MEMORANDUM

TO: Jean Fraser, Planner
FROM: David Senus, P.E. & Ashley Auger, E.I.T.
DATE: November 20, 2013
RE: Munjoy Heights, Level III Site Plan Application

Woodard & Curran has reviewed the Final Level III Site Plan Application for the proposed infill residential development located at 79 Walnut Street in Portland, Maine. The project consists of the demolition of two structures and the development of 29 townhouse style residences.

8-IN FIRE LINE METER DETAIL

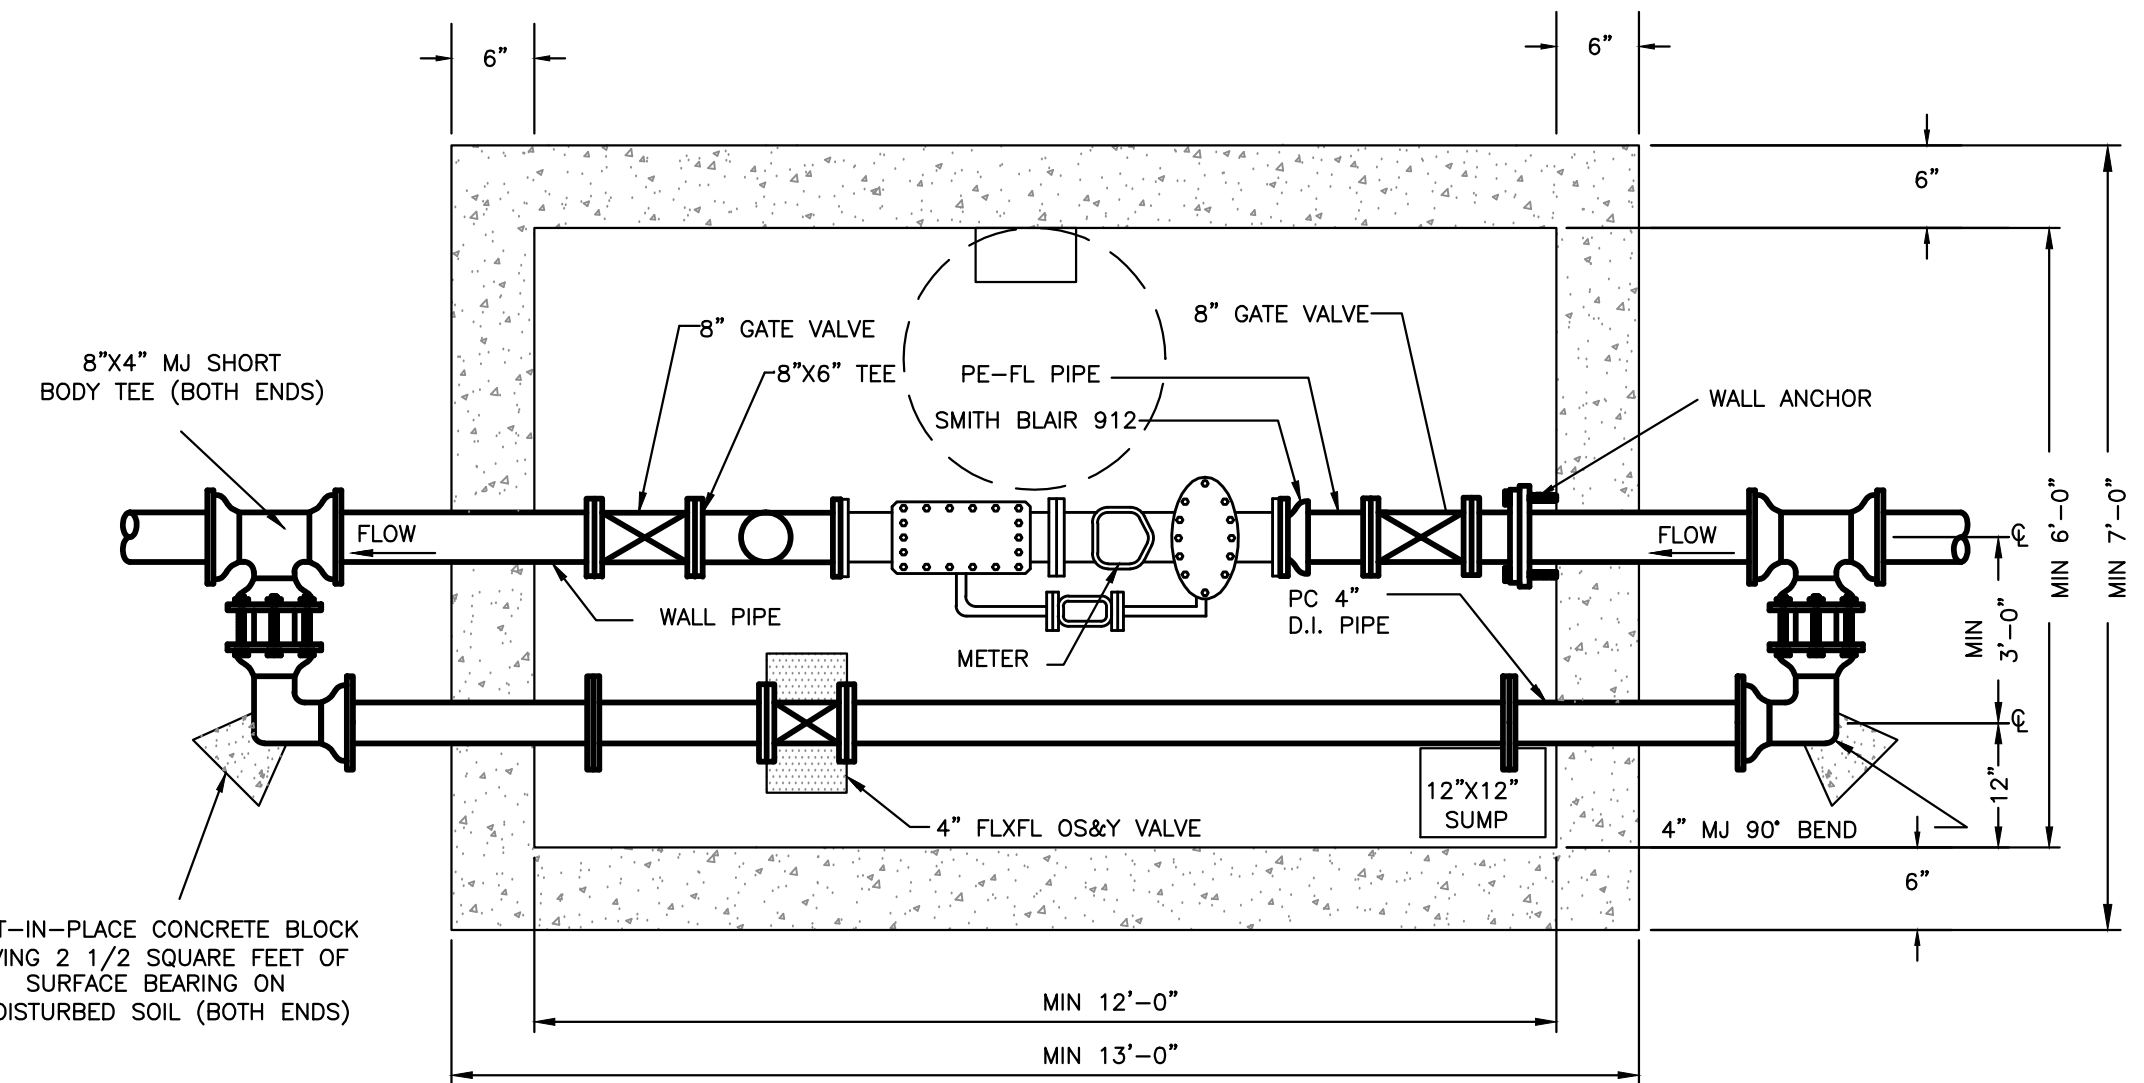
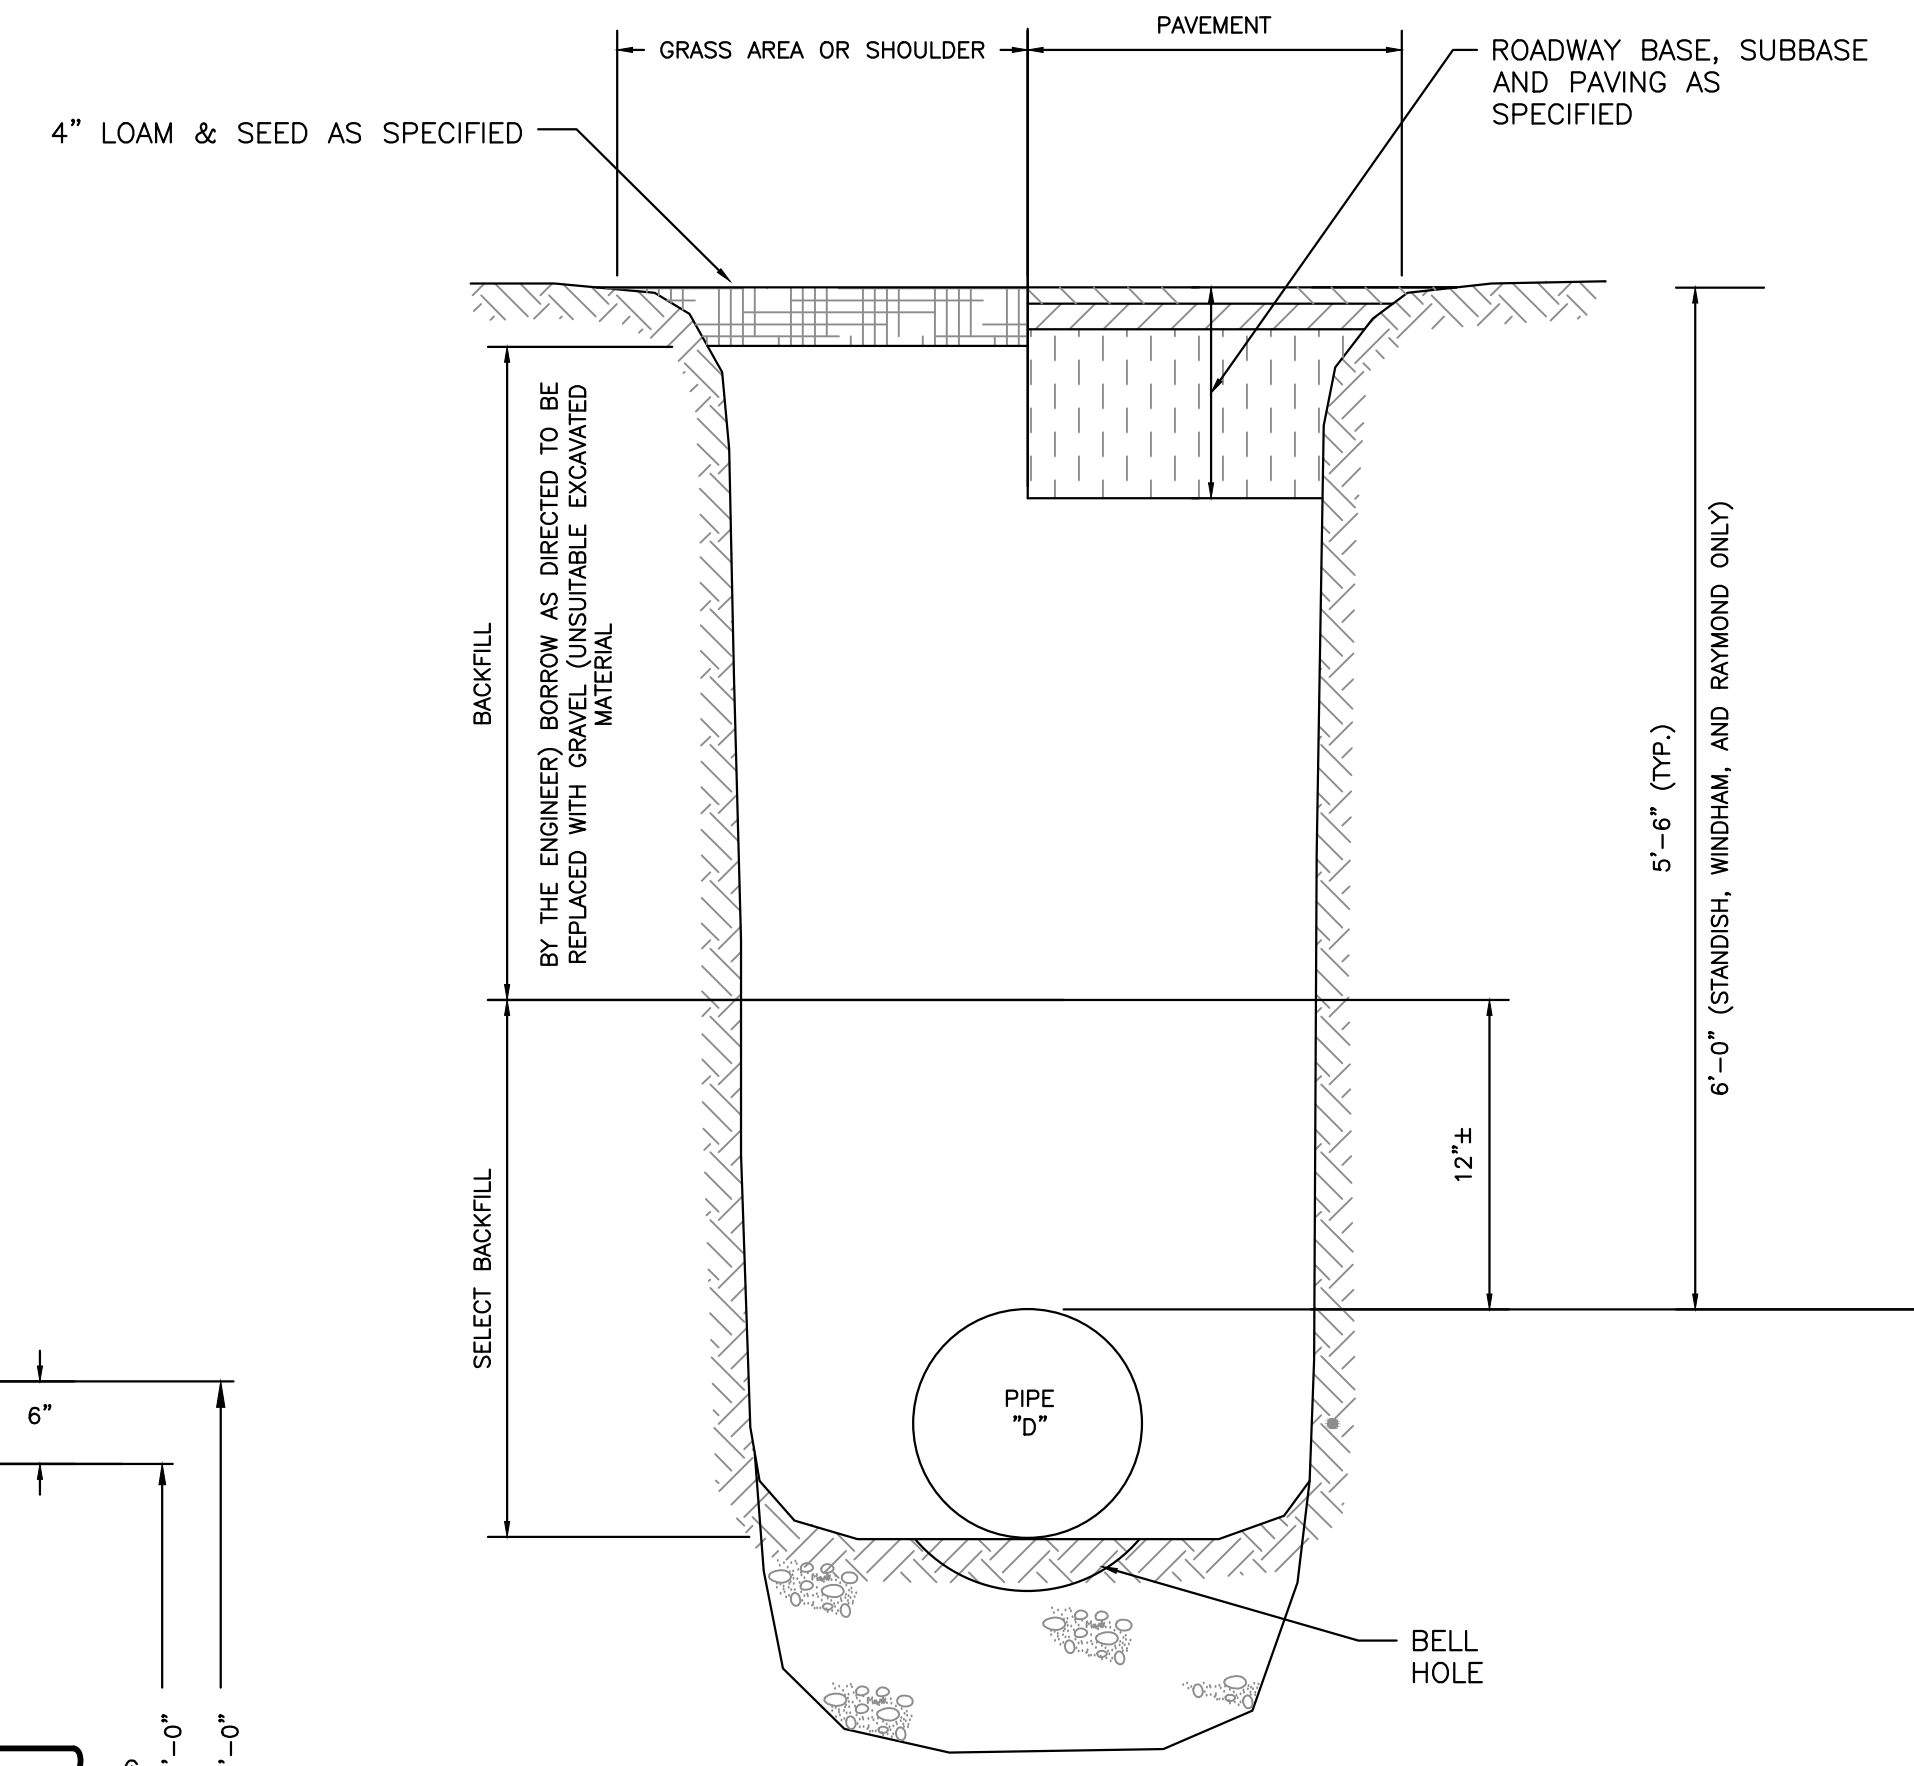
- 16) Sheet C-20, it is unclear how fire and domestic water services can be provided to Units 1,2 & 3 given the location of the fire meter pit relative to the building.
